REFERENCE	DE-2026/21
Date	30 March 2026

EXHIBITION OF STATE SIGNIFICANT DEVELOPMENT APPLICATION
CORRIMAL COKE WORKS – STAGE 2-4 EARLY STAGE (CIVIL WORKS)

Development	State Significant Development - Corrimal Coke Works – Stage 2-4 Early Stage (Civil Works) (SSD-86131212) - Request to Provide Advice on the Environmental Impact Statement (EIS)
Location	Lot 103 DP 1301632 Lots 3, 4 and 8 DP 1313981 Corrimal Cokeworks, Railway Street CORRIMAL NSW 2518

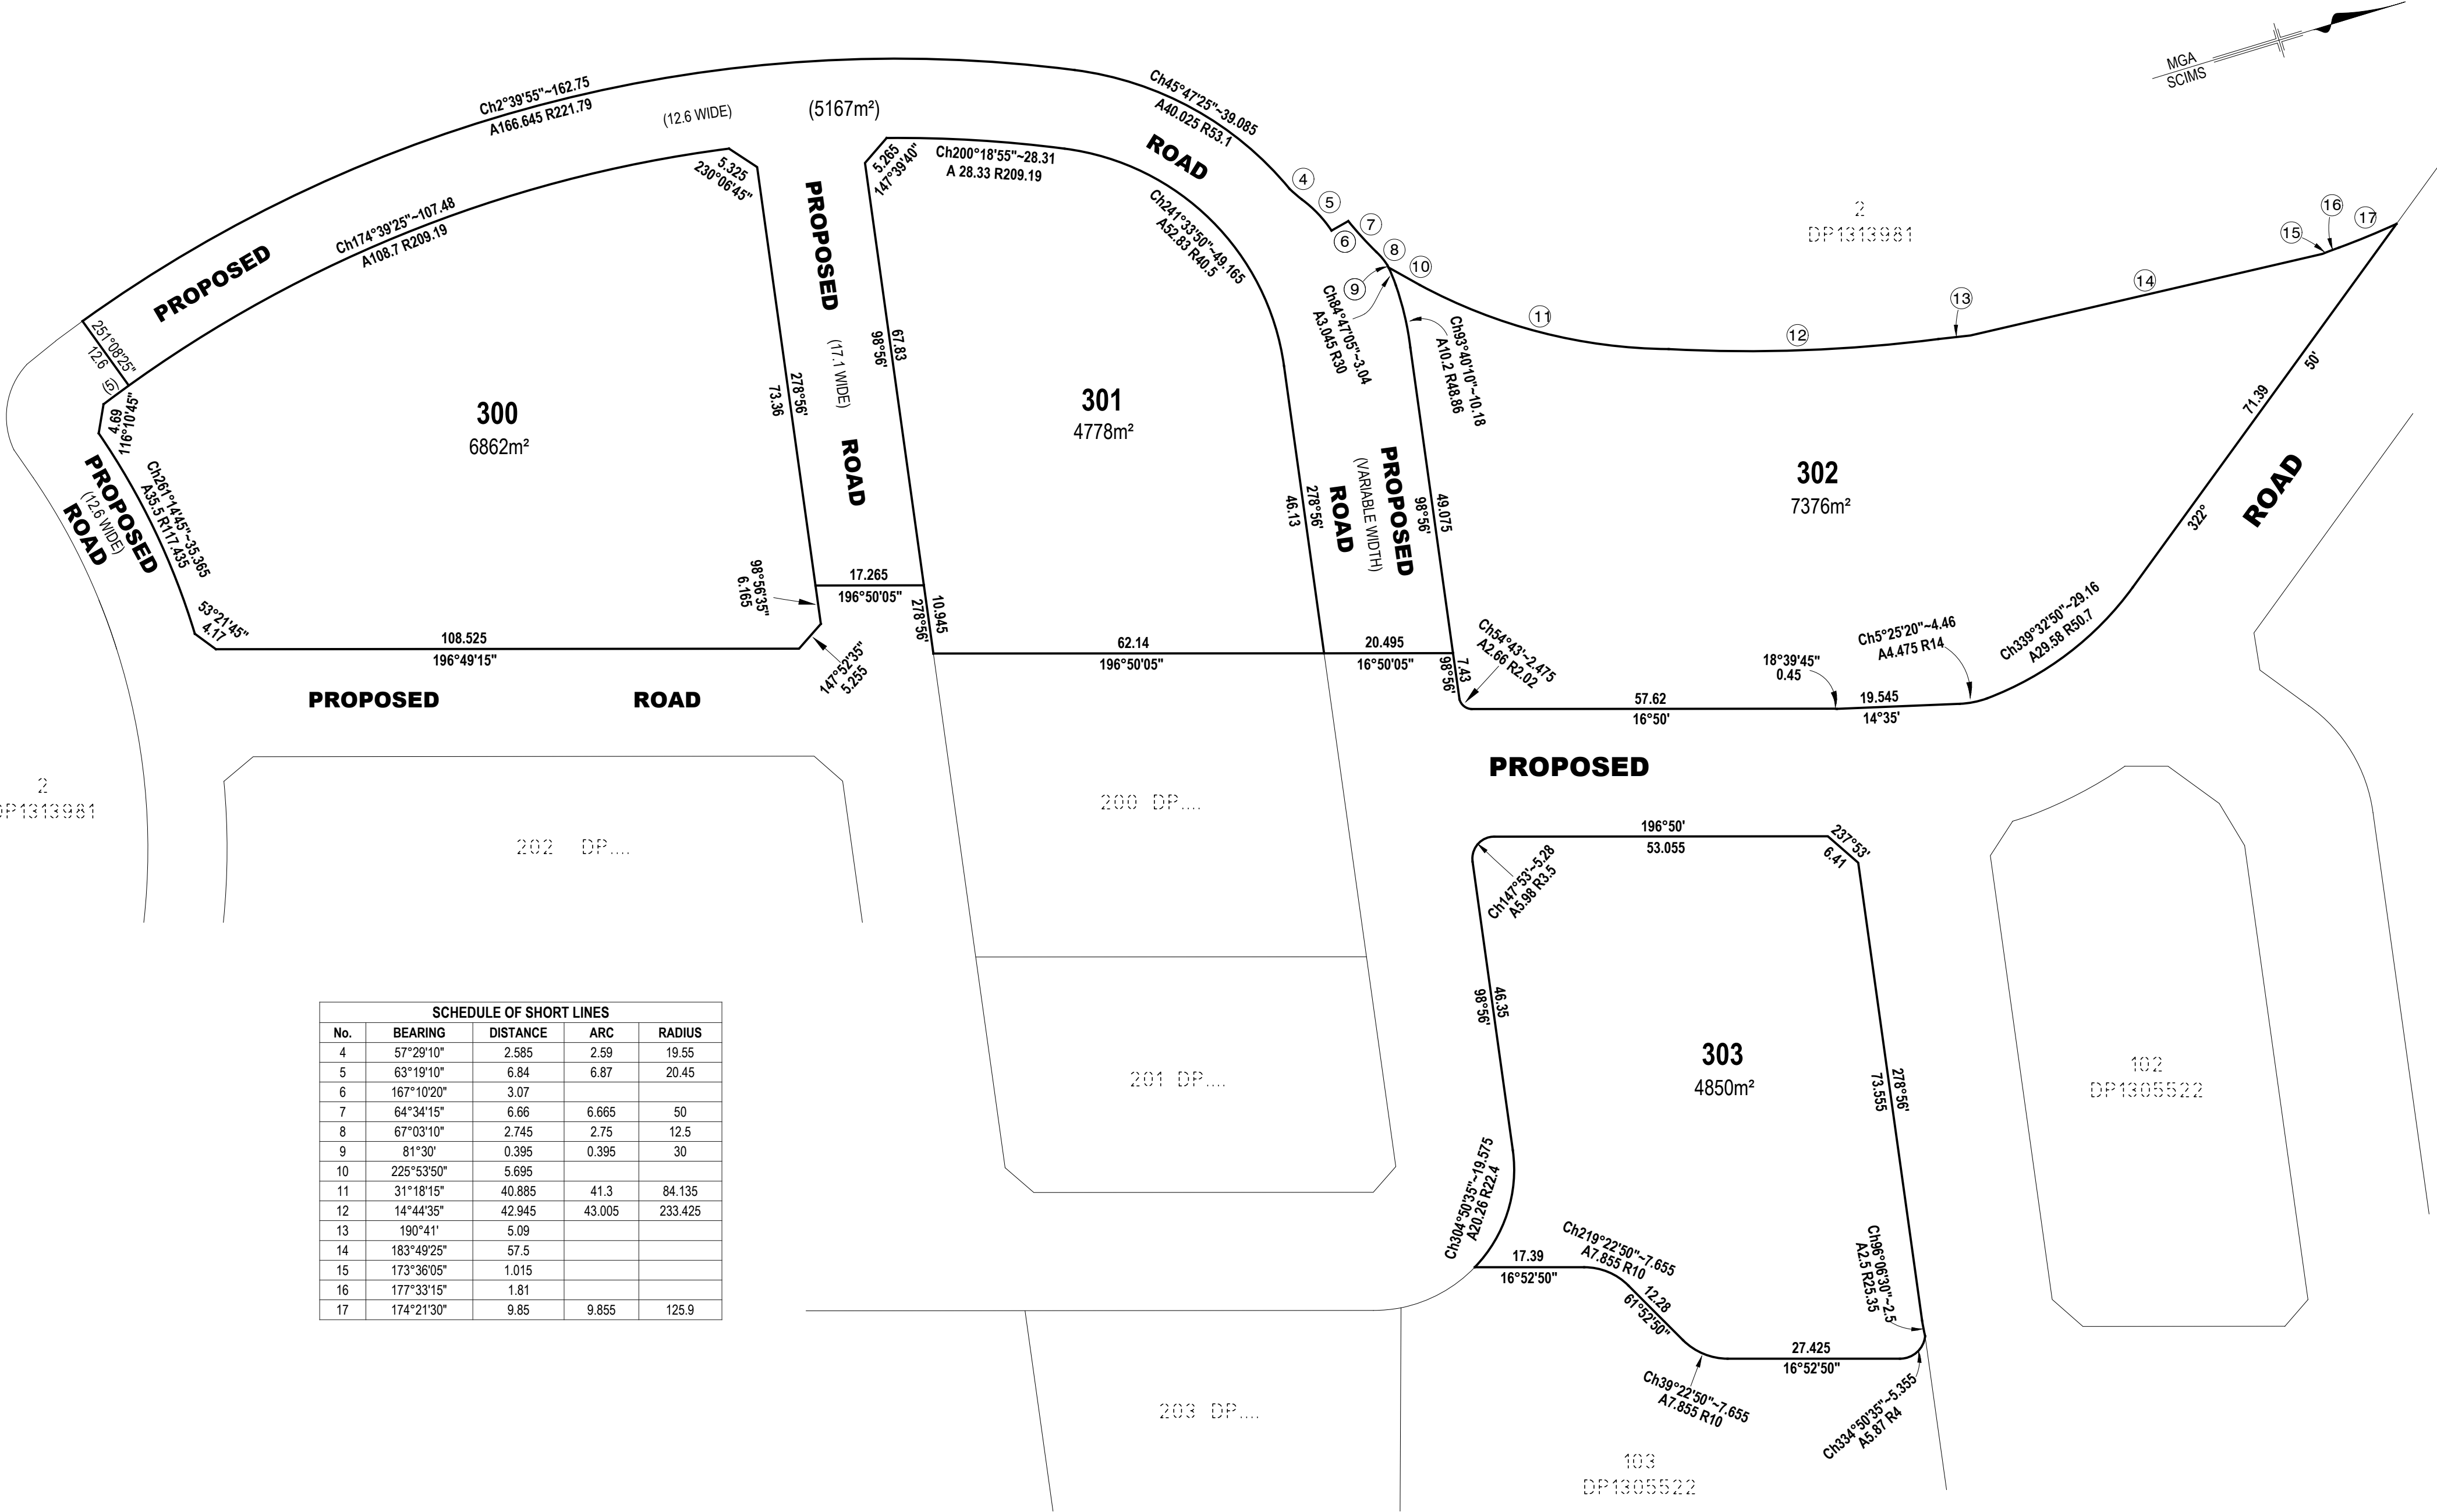
- The Staging Layout Plan (Dwg MKR00452-11-C0060 7) does not identify when the Southern Park will be delivered.
- The submitted Plan of Subdivision prepared by SDG only shows the subdivision of 4 lots, being proposed Lots 300-303 whereas the proposal is for the creation of 9 lots as part of Stages 2-4. The lot layout plans prepared by Maker (Dwg No. MKR00452-11-C0050) reflect the 9 lots proposed. It is unclear why the plans are inconsistent.
- Table 6: Site and Locality Description in the exhibited EIS excludes the Stage 4 commercial lot (Lot 303) from the red 'Stage 2-4 Civil Works SSDA' boundary whereas the submitted subdivision plans include this lot.

The current SSDA involves a minor boundary adjustment to this lot. The positive covenant (and all other easements) must be transferred across to proposed Lot 303 to ensure the outcomes for the Heritage Plaza are achieved and the commitments under DA-2023/550 are met. All relevant easements and restrictions should be shown on the Plan of Subdivision.
